**From:** Collins, Cameron <Collins.Cameron@wagga.nsw.gov.au>  
**Sent:** Friday, 25 February 2022 4:10 PM  
**To:** Tatsiana Bandaruk  
**Cc:** Iwan Davies  
**Subject:** RE: Project EnergyConnect (NSW - Eastern Section) (SSI- 9172452) - Request for Advice on EIS

Councils primary concerns relate to the establishment of the Wagga Wagga Construction Compound and the impact of the project works primarily in regard to Council's road infrastructure.

Figure 4-14 Site of the proposed construction and compound accommodation camp sites at Lockhart and proposed construction compound site at Wagga Wagga

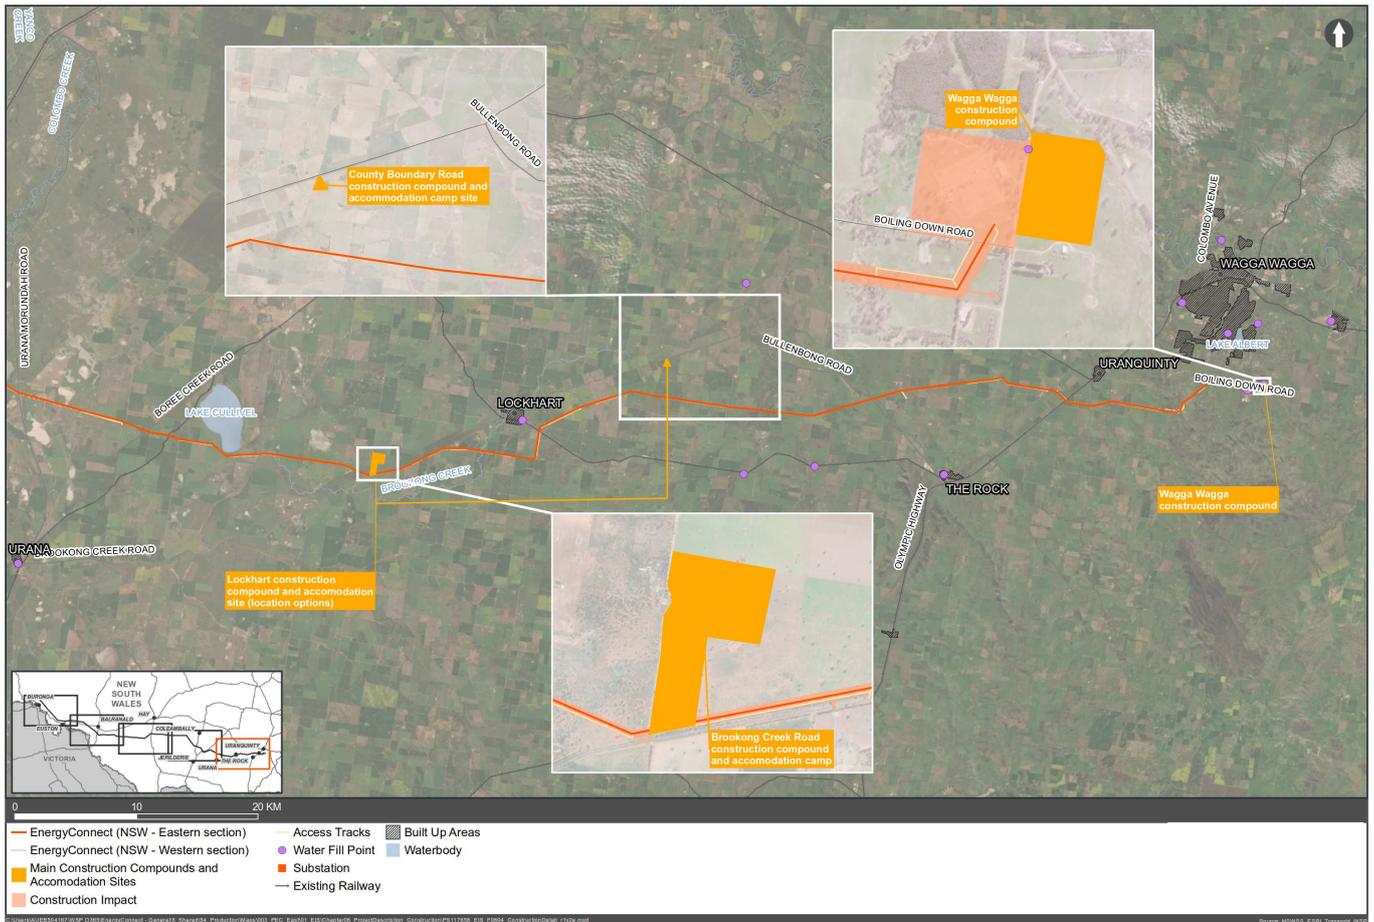
The application details the location of the proposed compound, however no further information can be identified with respect to the development of this area.

Any consent should require that final details of the design and layout of this compound be submitted for approval prior to commencement of any work associated with its establishment. This should include as a minimum:

- Final access location and design details of intersection works within the Ashfords Road.
- Setout of temporary structures, temporary site buildings, storage areas and vehicular movement areas.
- Appropriate buffers and protections measure for existing drainage lines and vegetation on the site. Note - parts of the site are subject to major overland flow flooding.
- Dust, sediment and erosion control measures.
- Stormwater management.
- On site waste management including sewage waste.
- Establishment of appropriate security fencing and buffer setbacks to boundaries including Ashfords Road.

The compound is located on land that is within the Lake Albert Catchment. Lake Albert is an extremely important recreation and environmental asset for the Wagga Wagga community. Matters identified above including stormwater management, sediment and erosion control, management of effluent waste and protection of waterways and vegetation are critical to the protection of water quality within this catchment.

The application does not examine the impact on the continued safe operation of Ashfords Road noting that the compound will act as the main staging area for the Wagga Wagga Substation upgrade and will likely necessitate the regular movement of equipment, materials and vehicles back and forth across the roadway. The proponent should consider the possibility of a smaller compound specifically for the substation upgrade on the western side of Ashfords Road to avoid this conflict. A further compound catering for the transmission line upgrade could then be sited in an alternate location more readily accessible to these works and also to primary supply routes (such as the Olympic Highway south of Uranquinty) thereby minimising haulage impacts on roads (and intersections) such as Boiling down Road, Ashfords Road and Gregadoo Road.

Alternatively, specific management practices will need to be in place to coordinate construction activity movements across the roadway without impinging on its continued operation which includes ongoing public access to Council's Gregadoo Waste Management Facility.

Rehabilitation of the compound needs to be addressed in any consent to ensure that the site of the compound is returned to its original status within a reasonable time frame following completion of works.

Figure 4-21 Approximate extent of the Wagga Wagga substation upgrade and expansion location

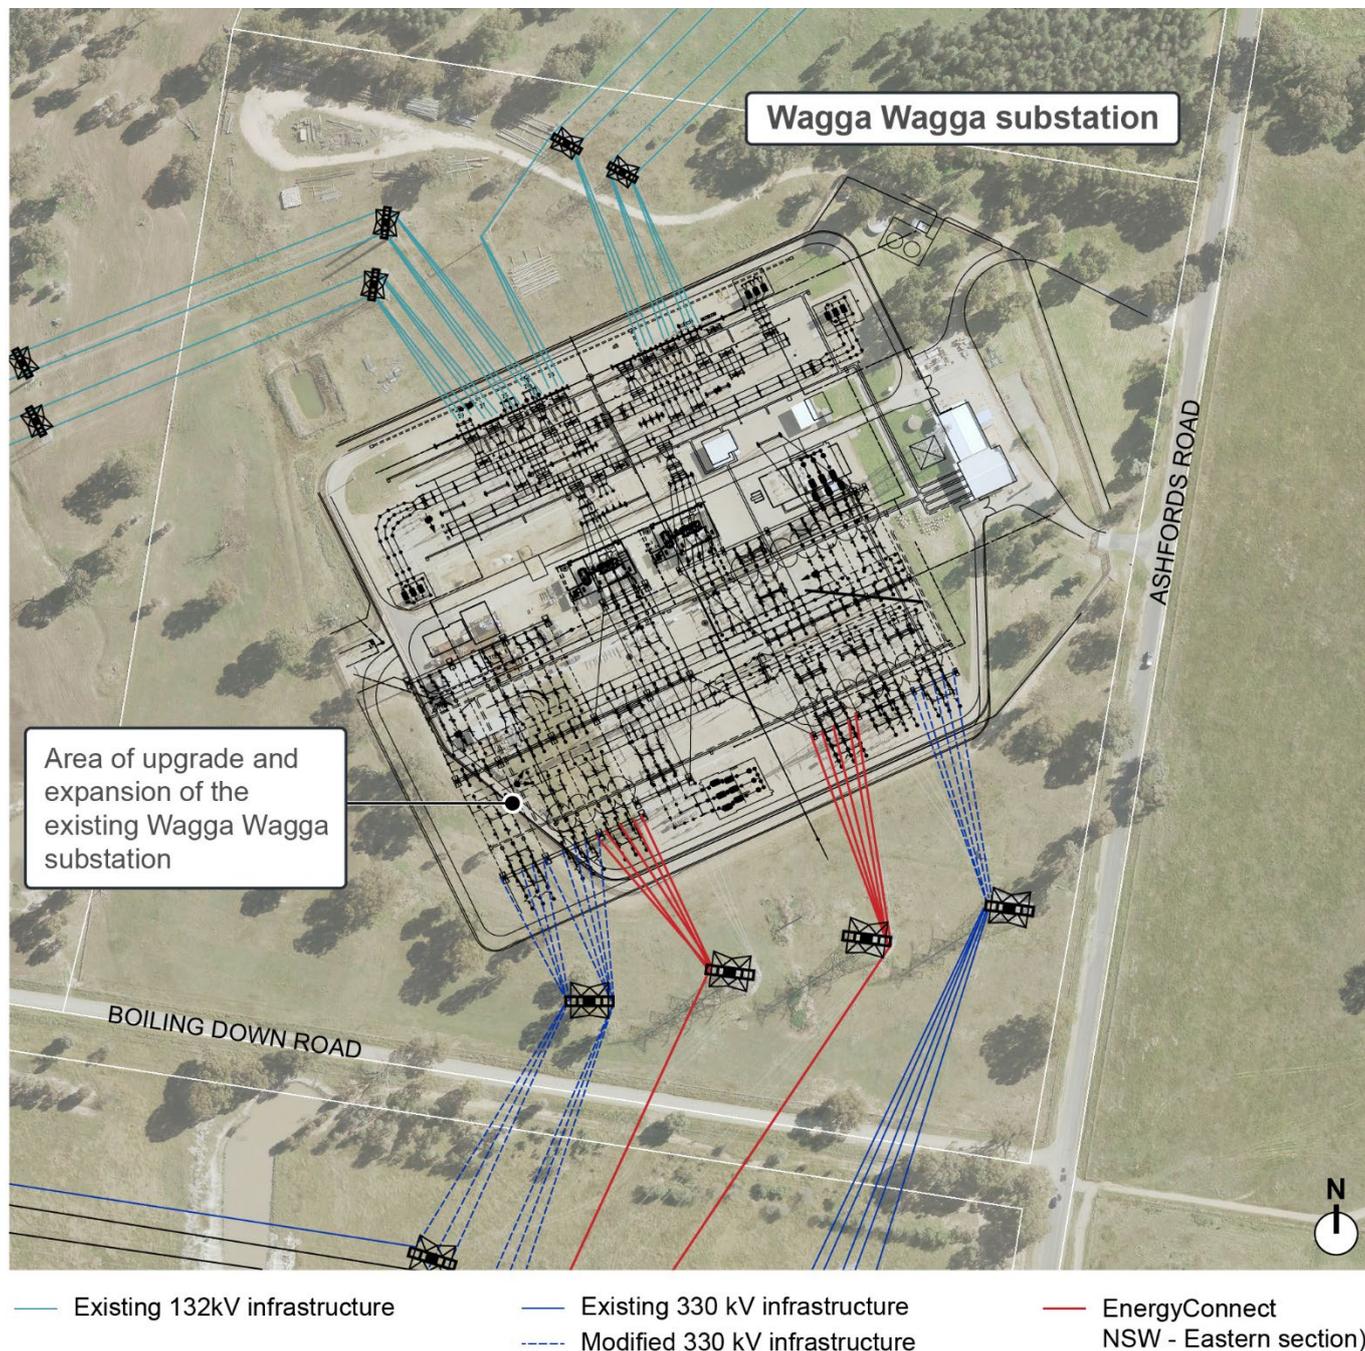
It is uncertain as to whether temporary construction access is proposed to the site during the upgrade. Any temporary access should have regard to the comments below and also consideration with respect to the comments provided above relating to construction activities across Ashfords Road.

The upgrade will require additional stormwater works that will connect into the existing stormwater management system on the site. It is uncertain as to where this system currently discharges to. Any works should ensure that this discharge point or any adjacent infrastructure is not impacted through the increase in rate or volume of discharge.
